National Highways Planning Response (NHPR 21-09) Formal Recommendation to an Application for Planning Permission

Council's Reference: 21/03267/OUT

Location: OS Parcel 0006, southeast of Baynards House Adjoining A43, Baynards Green

National Highways Ref: 92857

Drawing Number: S1299-P-13

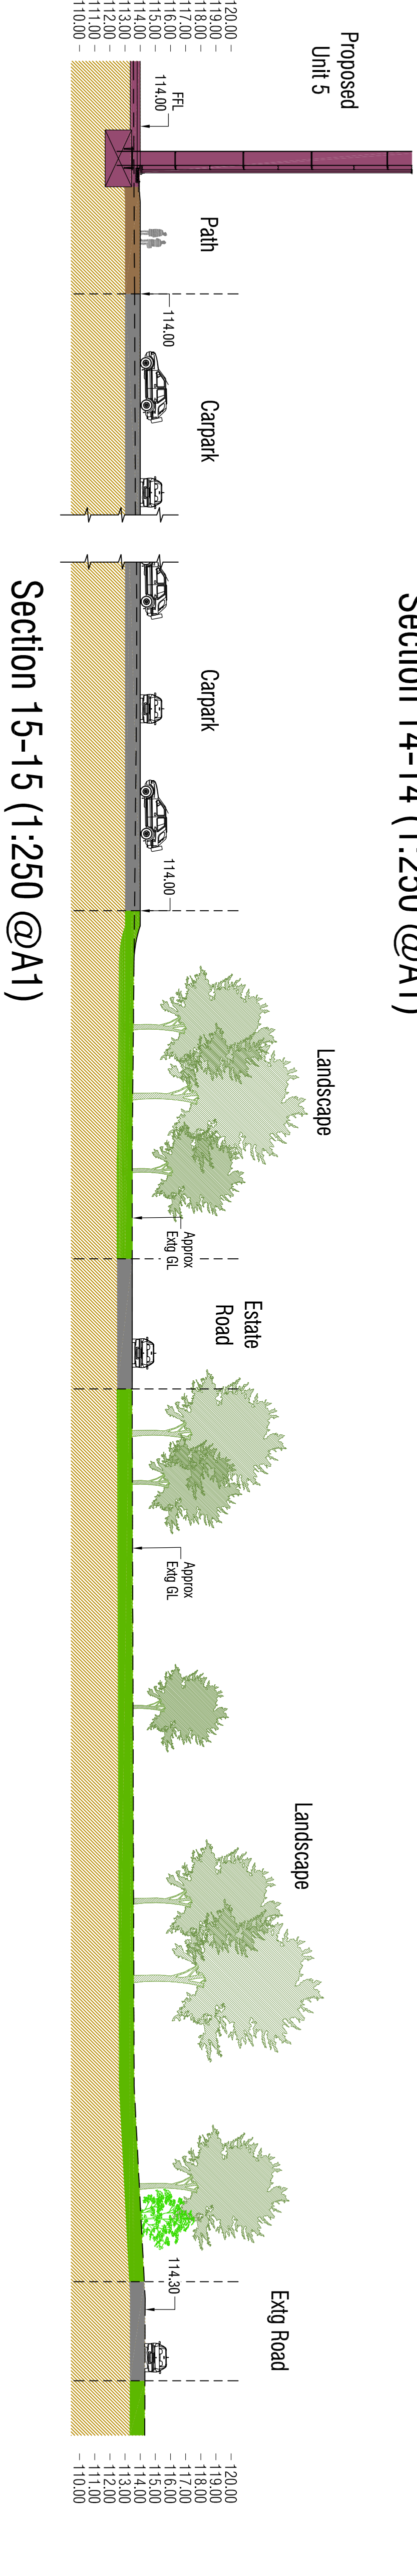
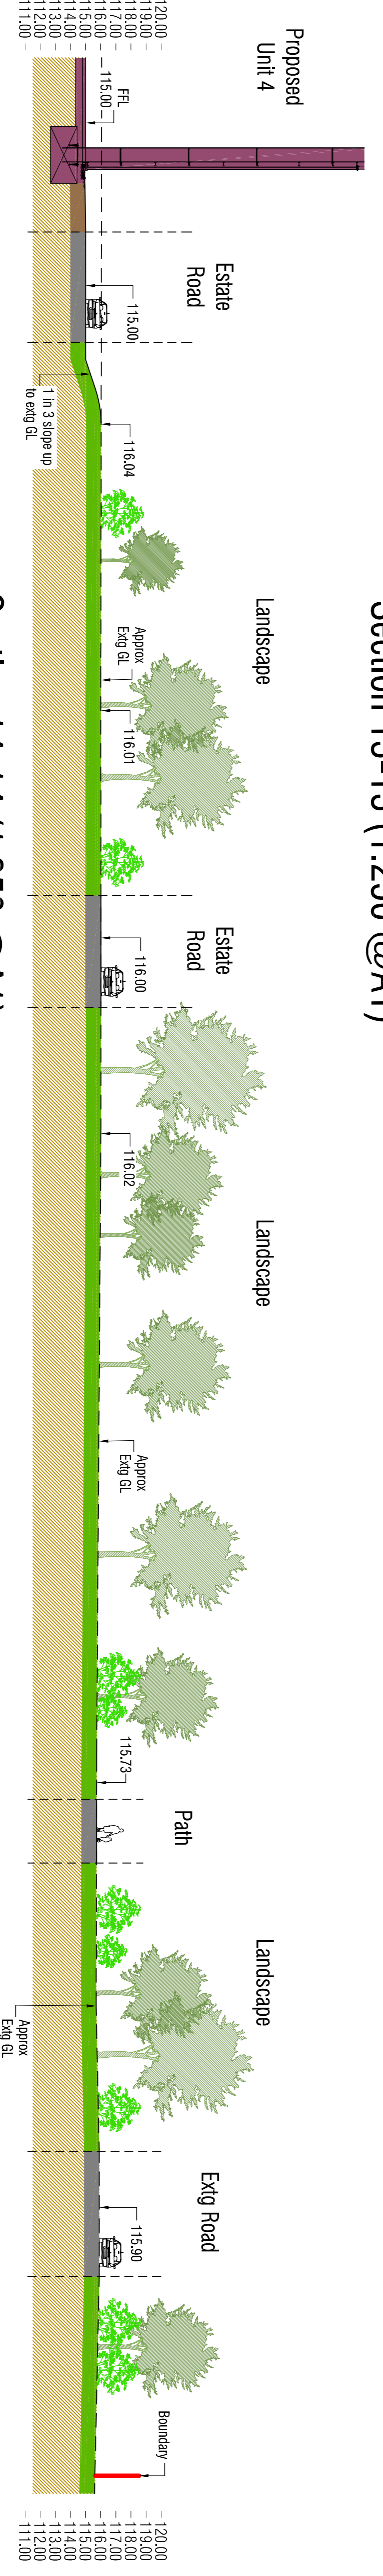
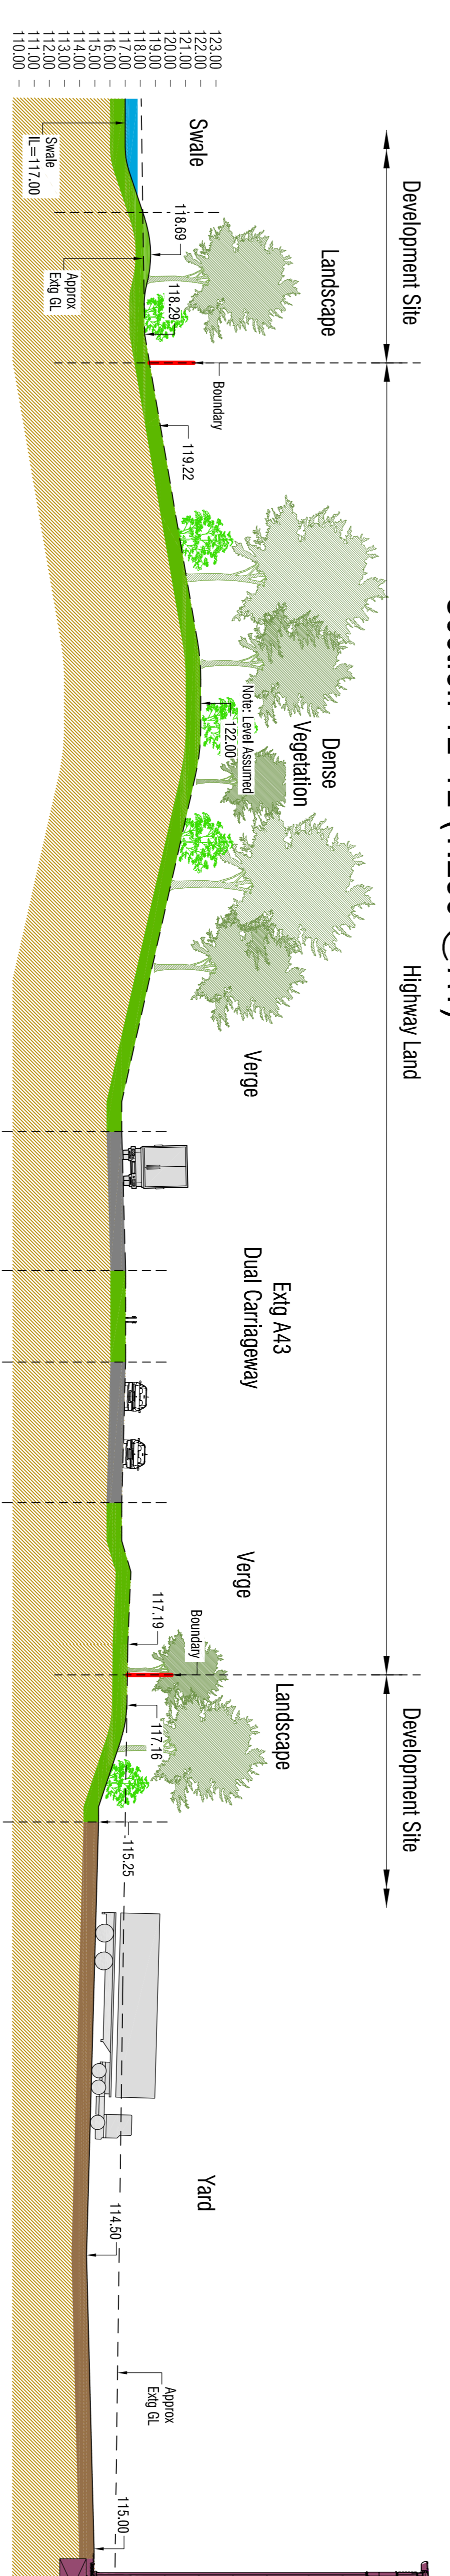
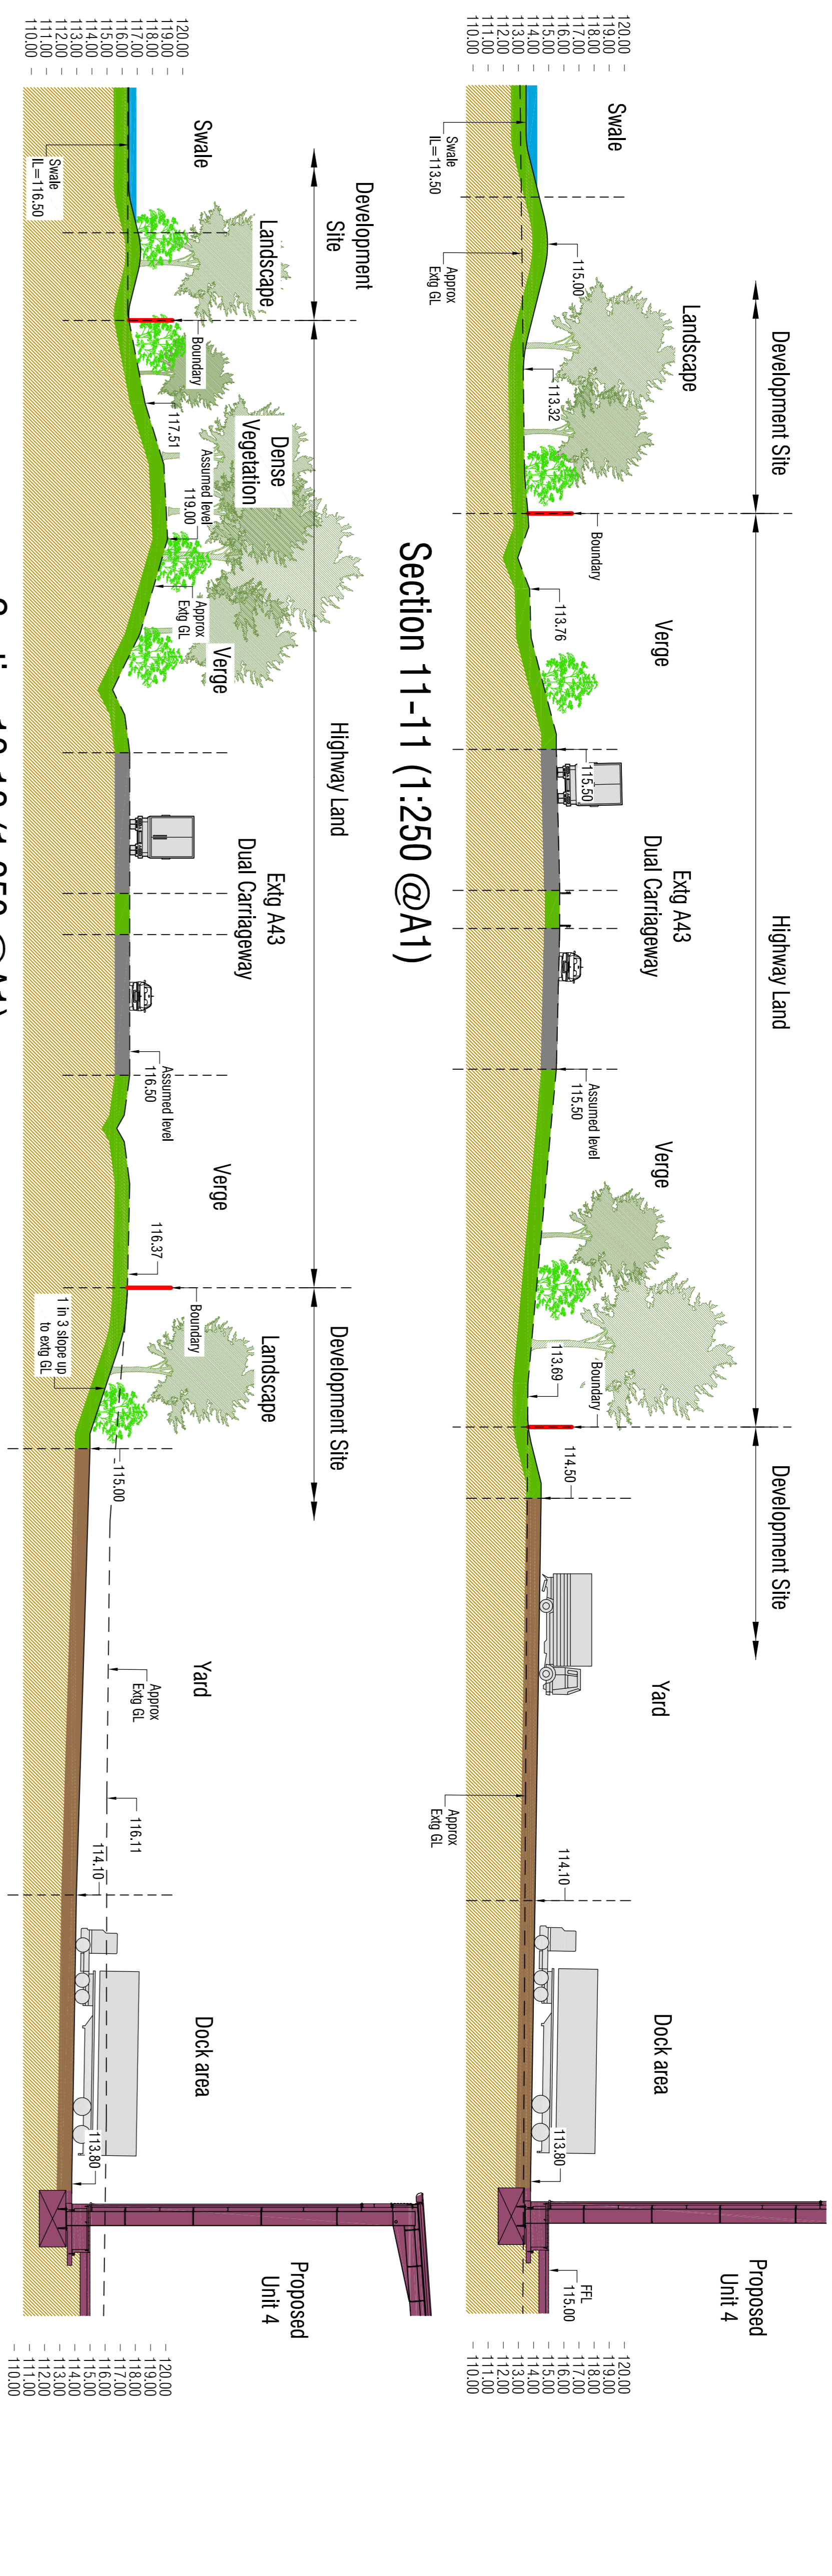
The applicant will need to advise / confirm if there will be any earthworks associated with the development(s) in relatively close proximity to National Highways boundaries

(e.g. the stability of the balancing ponds, etc). In the first instance, some cross sections (to scale) through the boundaries showing the proposed extent of the development, its features and any proposed changes in elevation (excavations, landscaping) etc should be submitted for further assessment. Once received, we will review to determine the possible extent of any geotechnical reporting under the Design Manual for Roads and Bridges (DMRB) standard CD 622, which may be required to confirm the extent of any geotechnical risk to the SRN.
